**RE: Meridian Service Metropolitan District
Water Treatment Plant Expansion
Site Development Plan – Comment Response Letter
PPR-22-012**

Below are responses to comments provided on 11/03/22 and 11/08/22 for agency review of the above-referenced project. We have inserted our responses and actions taken in **blue** below each comment.

**C2**

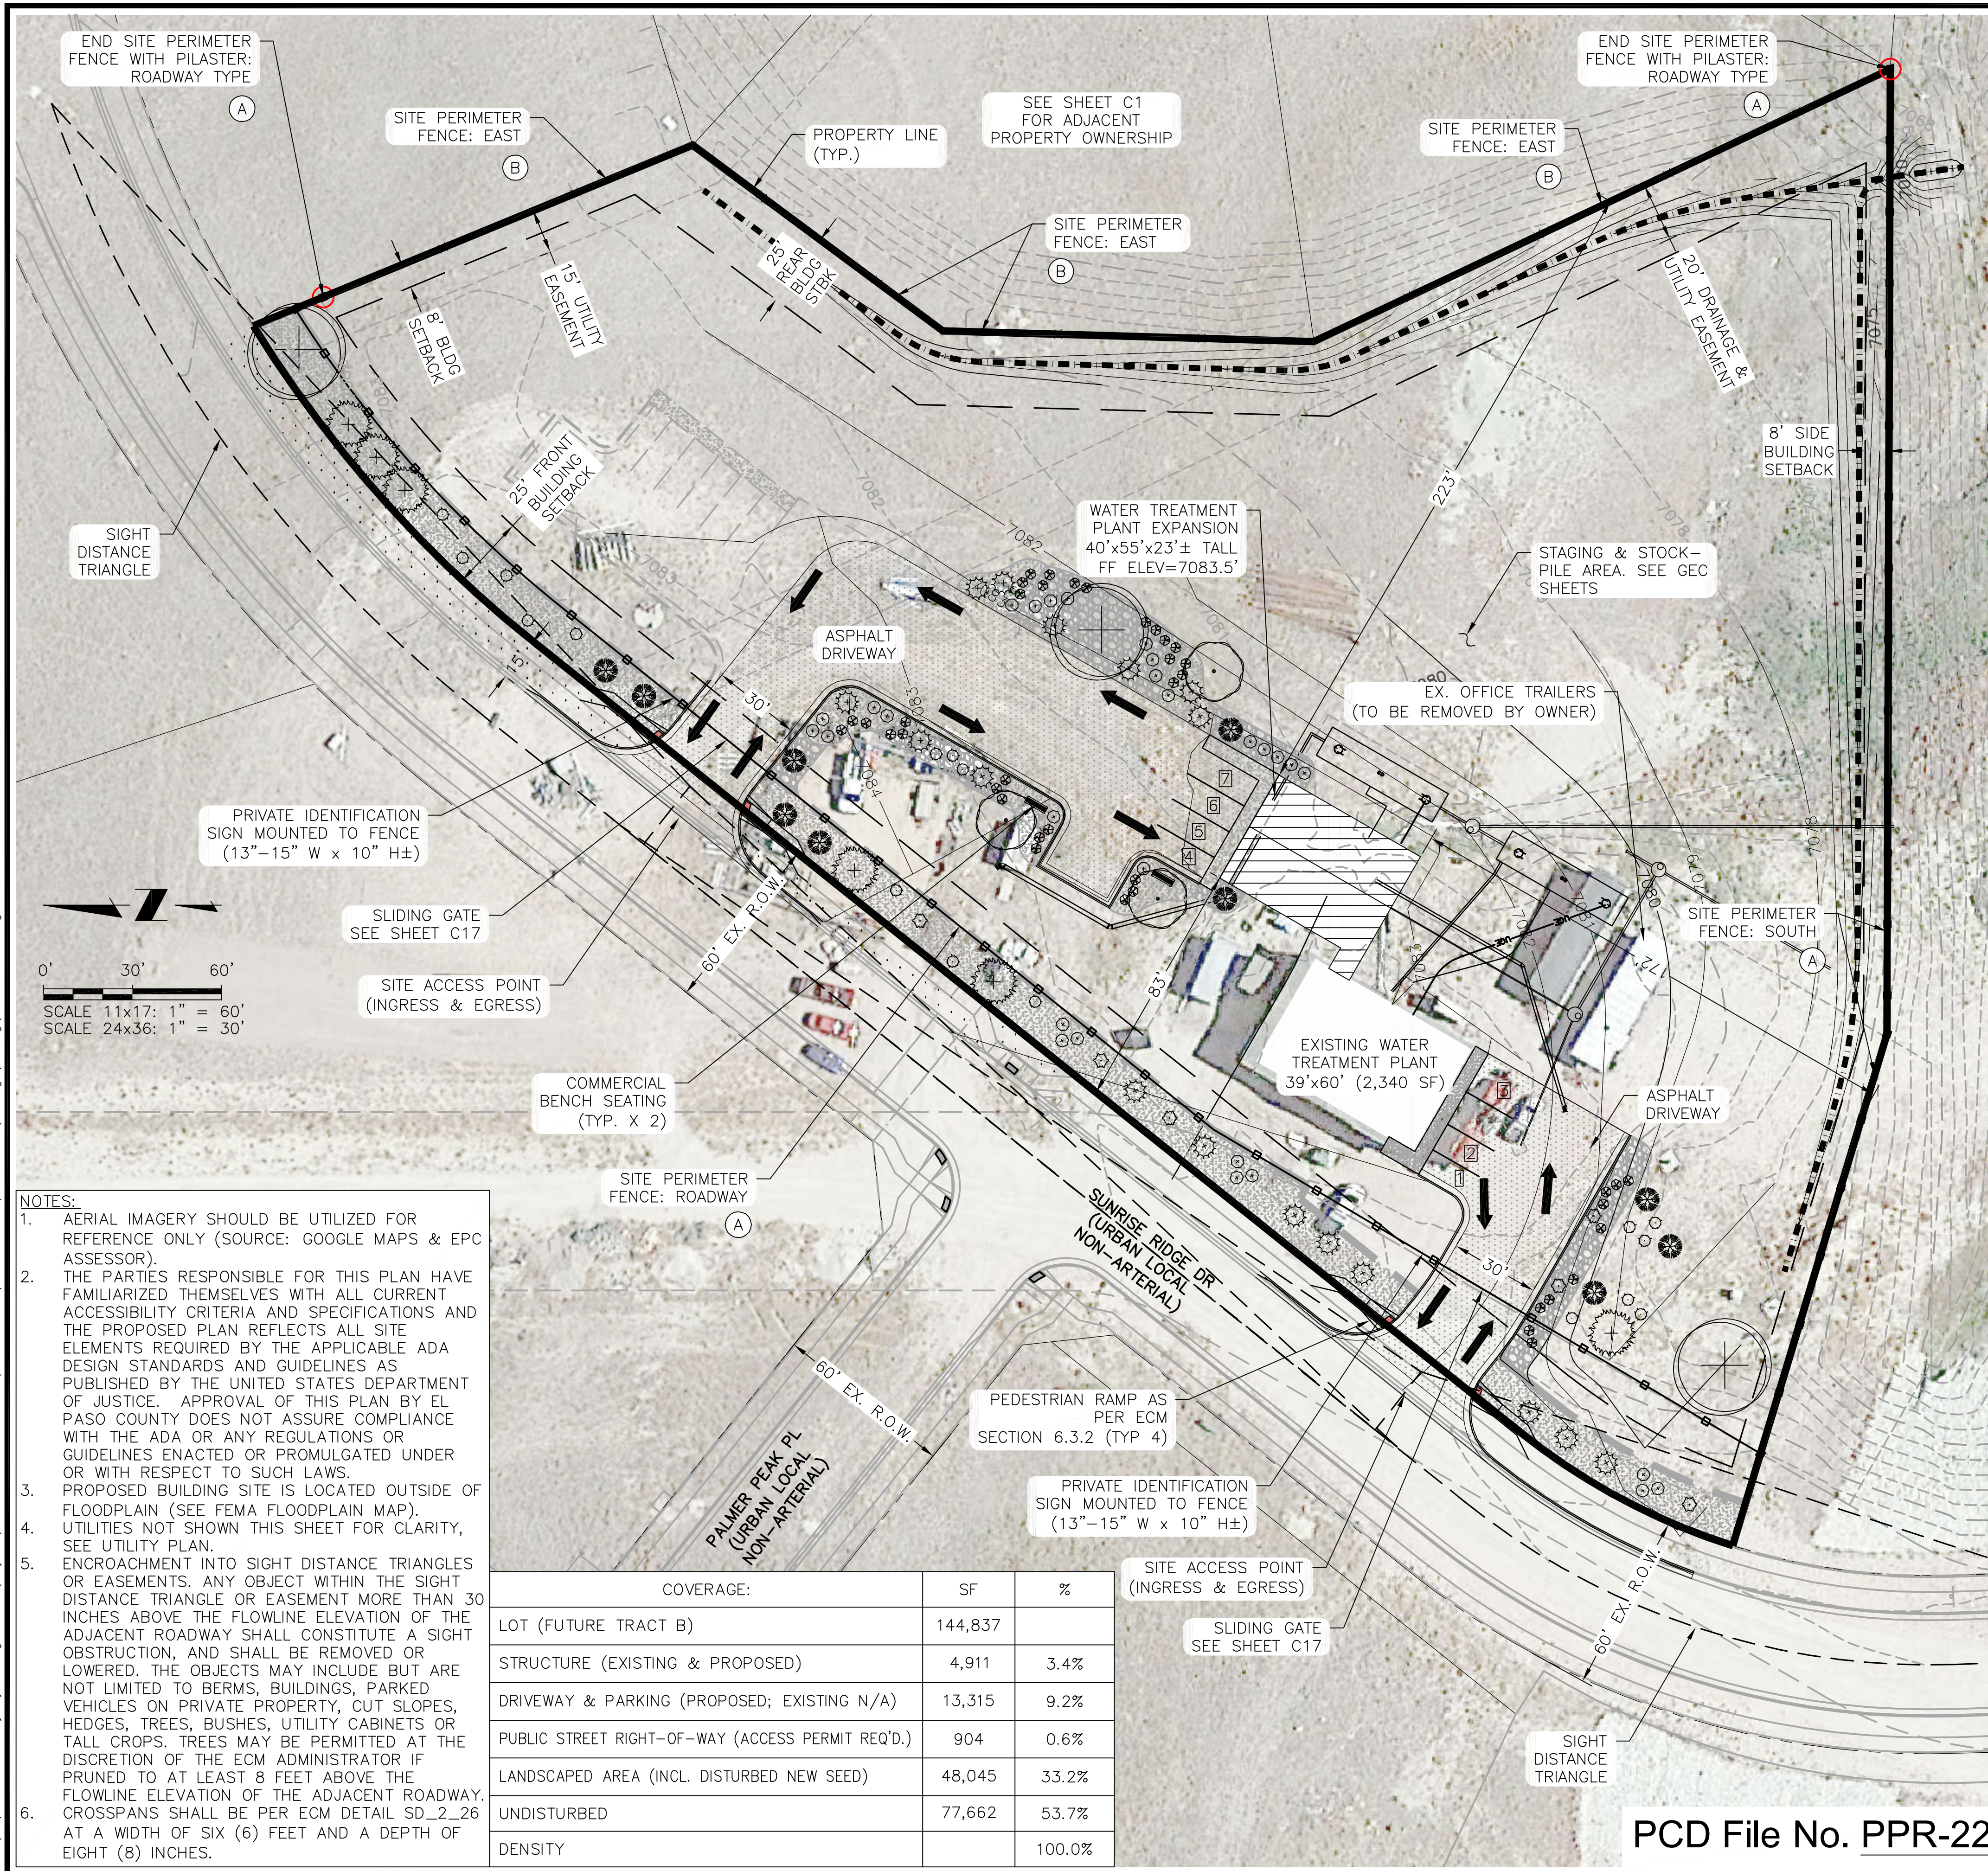
1. Site Development Plan
 - 1.1 "Please correct two parcels were combined to form Tract B 1.61 and 1.72=3.33ac. Scale shows area ~3.3ac. Note: Assessor site still shows two separate parcels for this tract. 4220203035, 4220203036"
 - 1.2 "Revise the entrances to standard driveway configuration with detached sidewalks. SD-2-25 and add std design detail to site plan"

Acreage correction included herein. It is noted the El Paso County Assessor site now includes the adjacent platted area with updated subject property lines shown. However, the area listed under Land Details has not yet been updated on the site.

After discussions with engineering and planning staff at PCD, the original proposed access driveways have been approved to match surrounding intersections for aesthetic purposes and larger vehicle access.

There are closed/locked security gates about 25 feet behind the back-of-curb to discourage residential traffic while still allowing operations vehicles to pull off the main road while waiting for the gates to open.

A note has been added to the Site Development Plan (Drawing C2, Note #6) stating that cross pans shall be six (6) feet wide and eight (8) inches thick.
